COMMUNITY DEVELOPMENT DEPARTMENT  
80 Columbia Avenue ♦ Marysville, WA 98270  
(360) 363-8100 ♦ (360) 651-5099 FAX

Re: Marysville Corporate Center – *Technical Review 1*  
PA 22004

RE: Marysville Corporate Center, File# PA22-004  
Binding Site Plan  
15908 47<sup>th</sup> Ave., Multiple Parcels

MARYSVILLE CORPORATE CENTER BINDING SITE PLAN FILE NO. _____

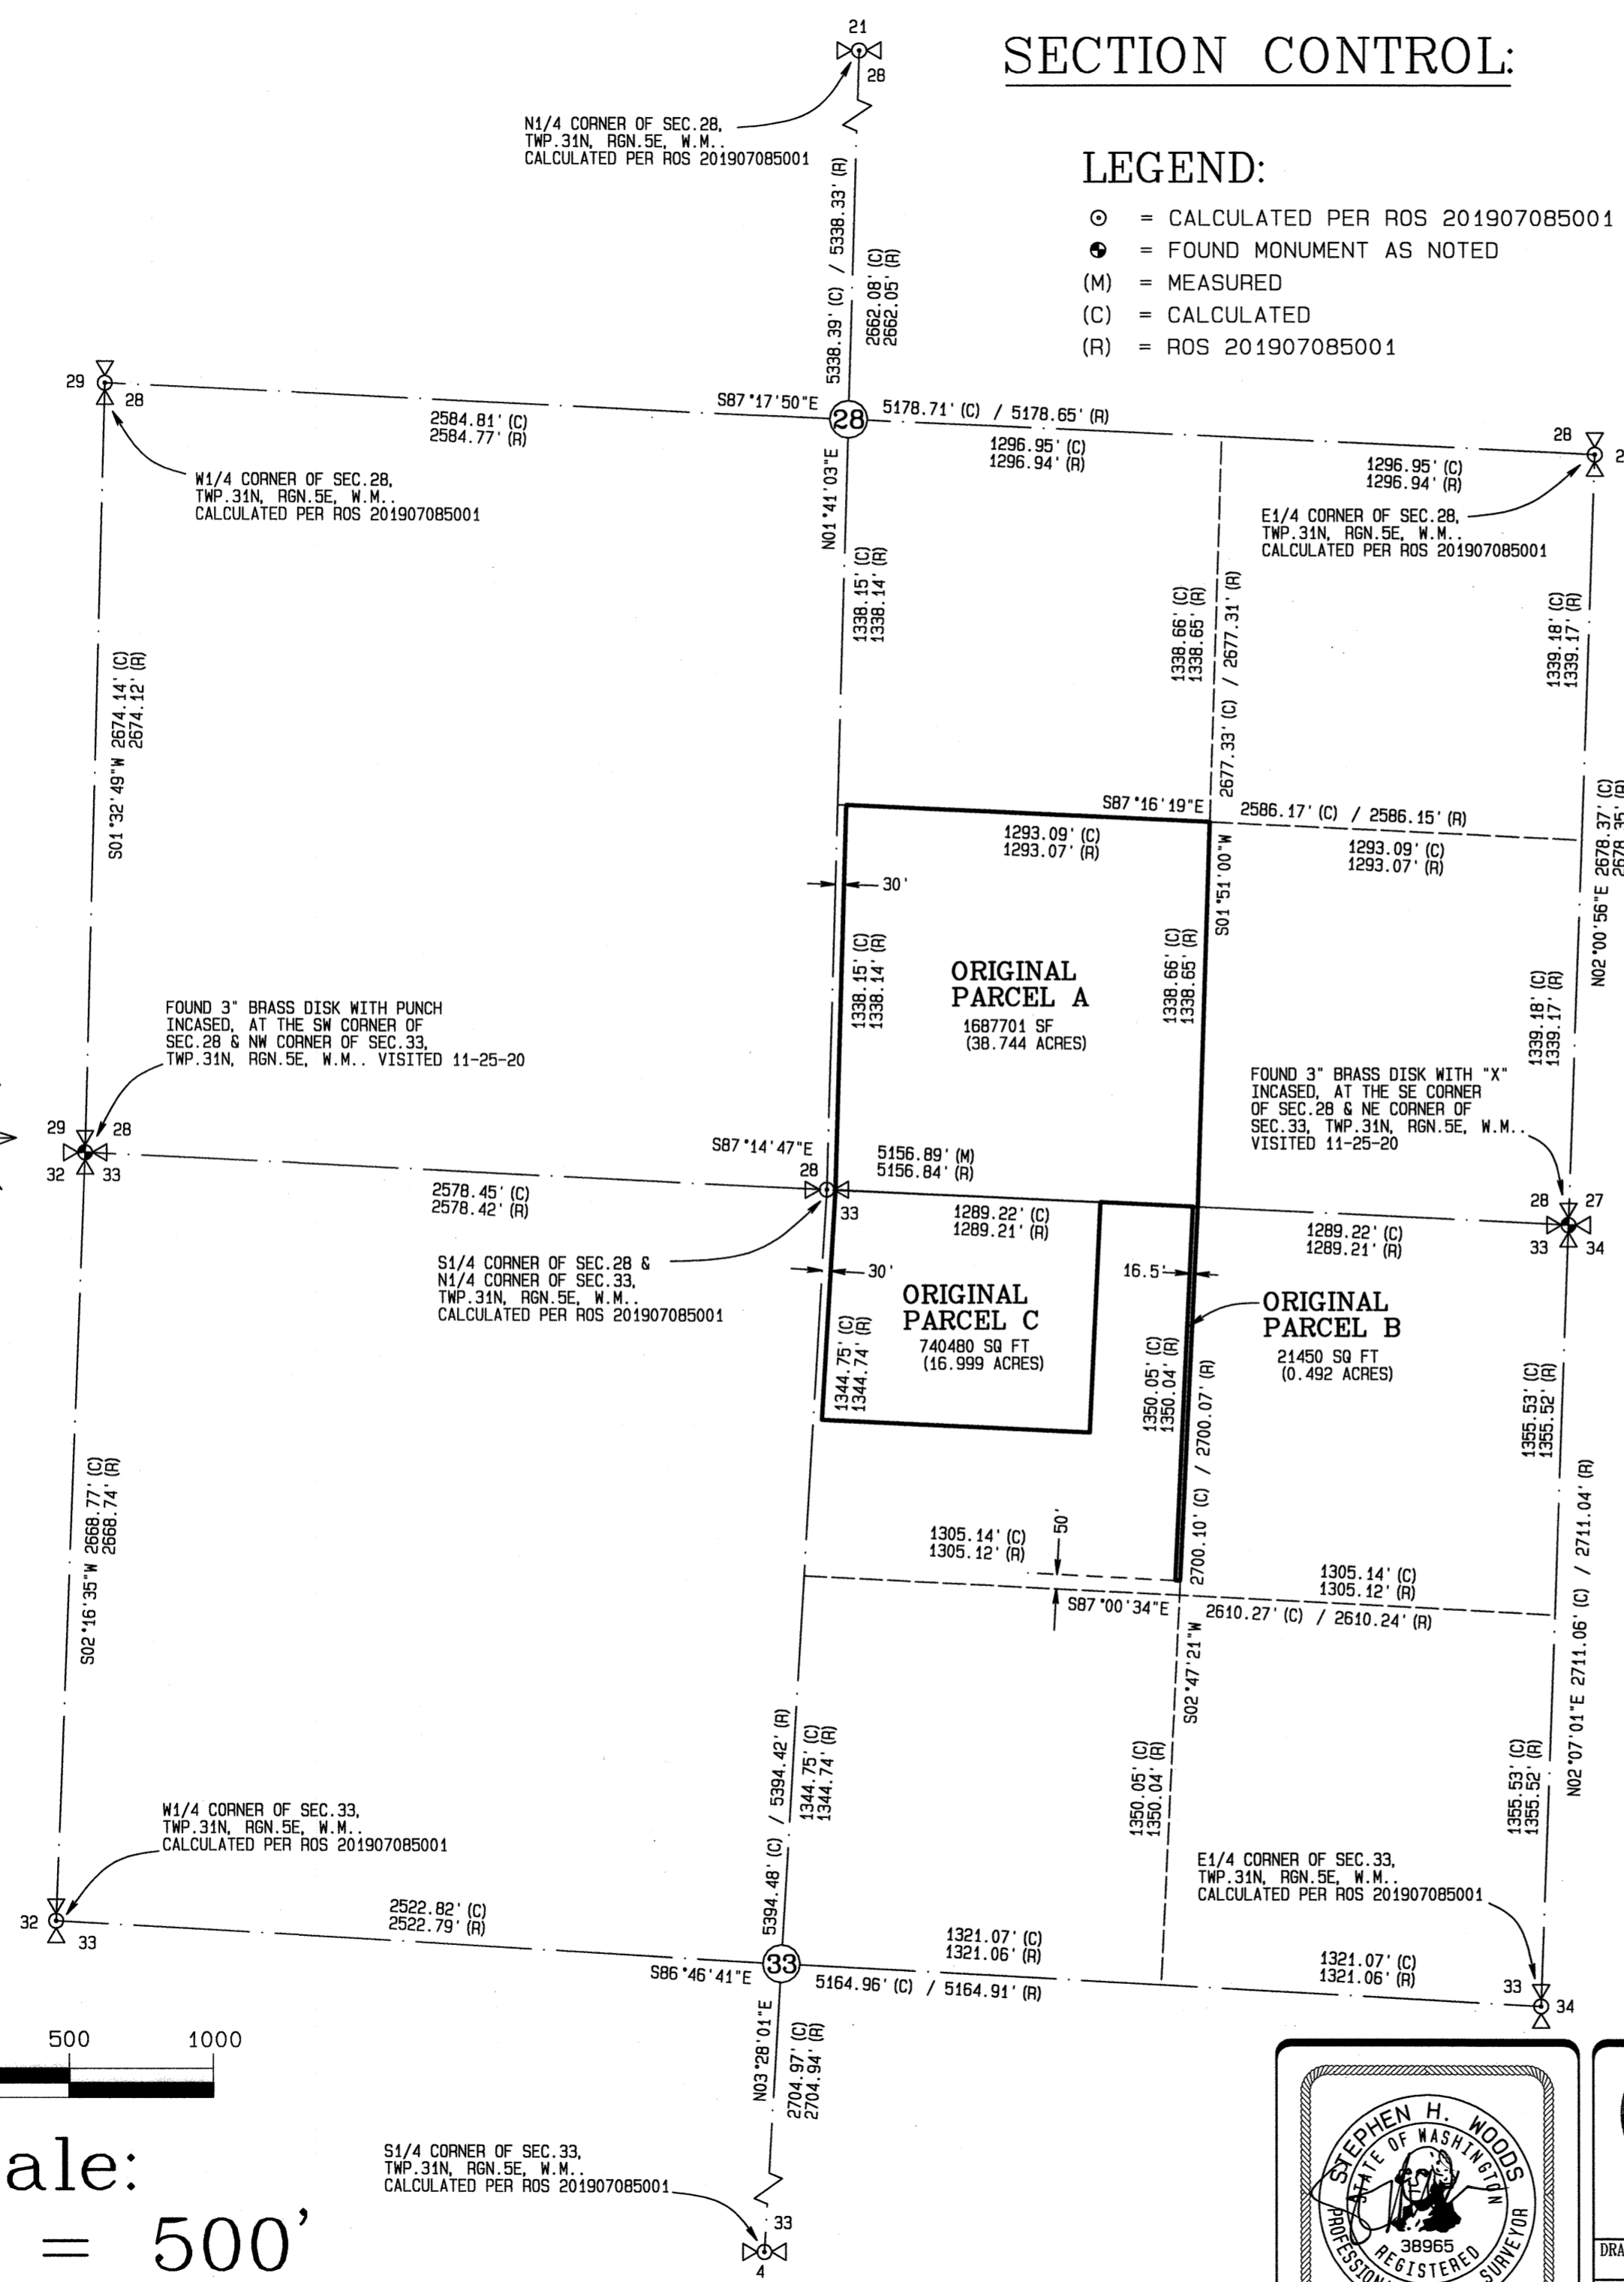
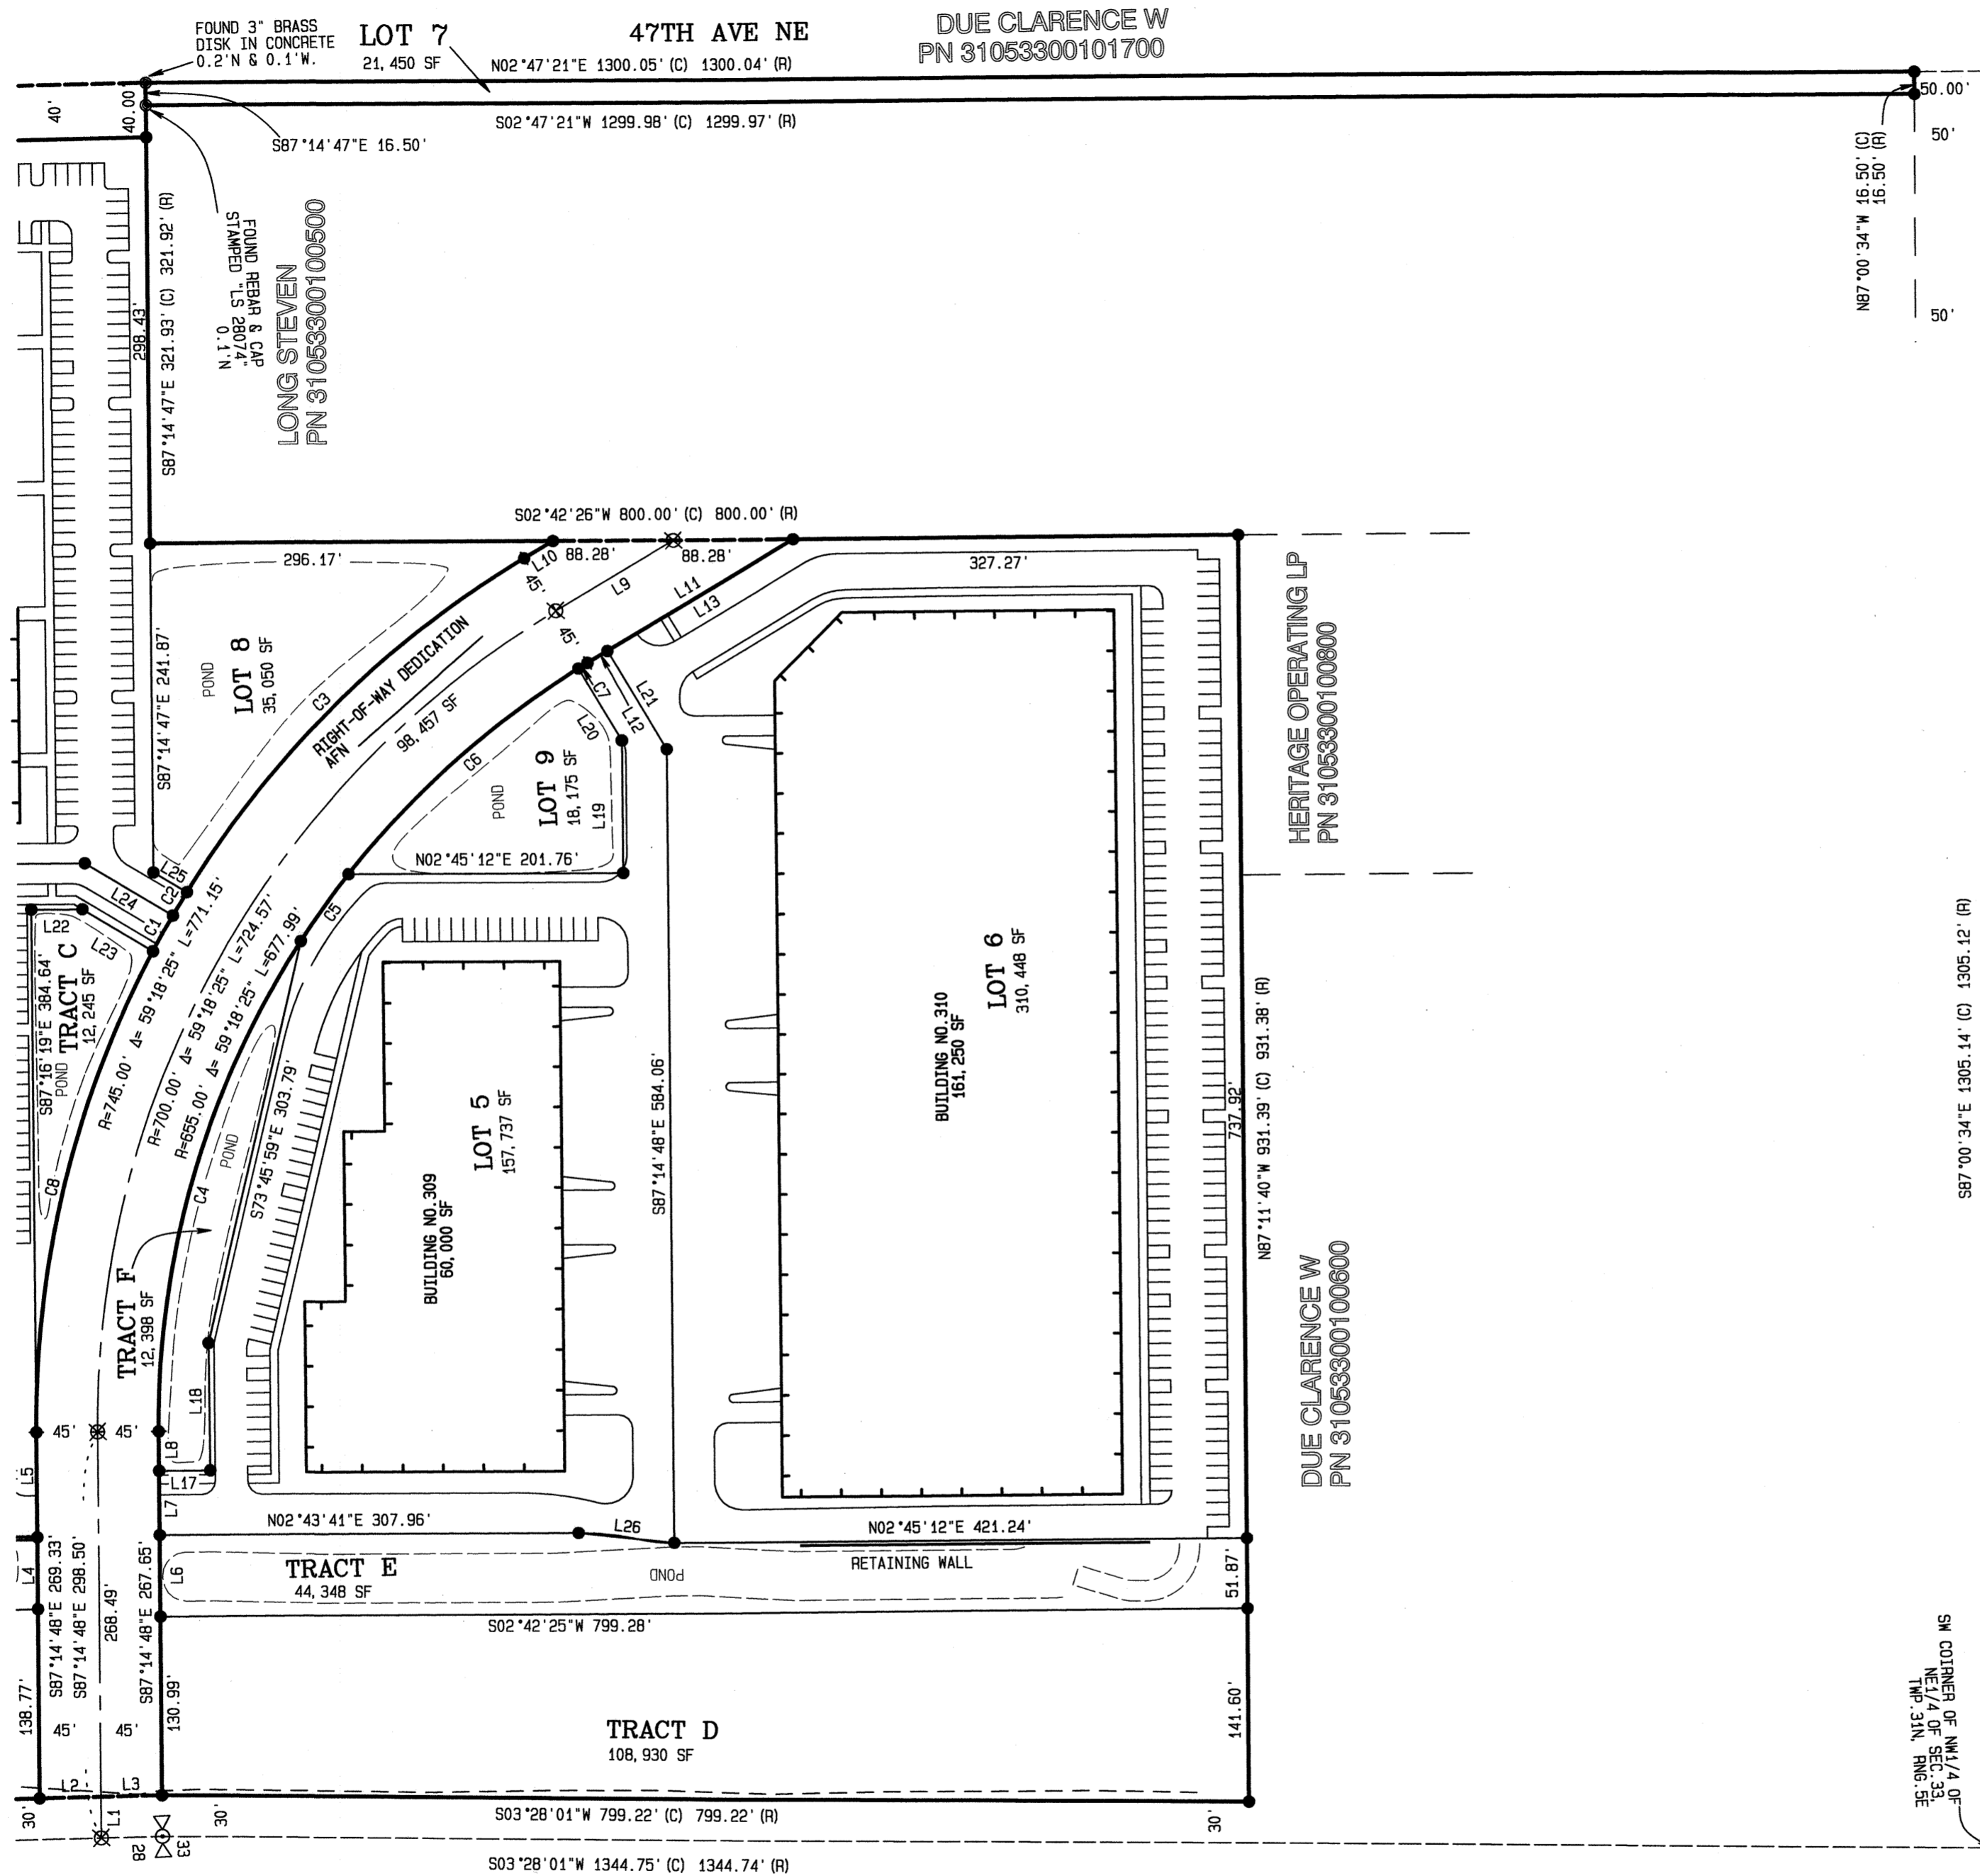
4. The preliminary BSP submitted is essentially a Final BSP. A preliminary BSP shall be required to be submitted, which includes the following information, as outlined in MMC 22G.100.090(3):

- a. See [MMC 22G.100.090\(3\)\(a\) – \(o\)](#) for all elements required to be depicted on the preliminary BSP. Most are included in the “Final BSP” submitted but will also need to be included on the preliminary BSP.

- b. Cover sheet should show entire boundary of site, including phasing lines.
  - c. Subsequent sheets shall be drawn in a reviewable scale (i.e. 1” = 20’, 1”= 30’, 1”= 40’ or 1” = 50’), pursuant to [MMC 22G.100.090\(3\)\(b\)](#).

- d. Phase 1, including all lots and tracts for all phases, shall be drawn with **dark solid lines**. With the recording of Phase 1 all lots will be created, however, individual site plan review will be required for development of subsequent phases.

- e. The interior layout of Phases 2 & 3 shall be drawn in **light colored shadow print**.
  - f. An existing conditions sheet will need to be provided, which depicts all encumbrances outlined in Schedule B of the Title Report prepared by Chicago
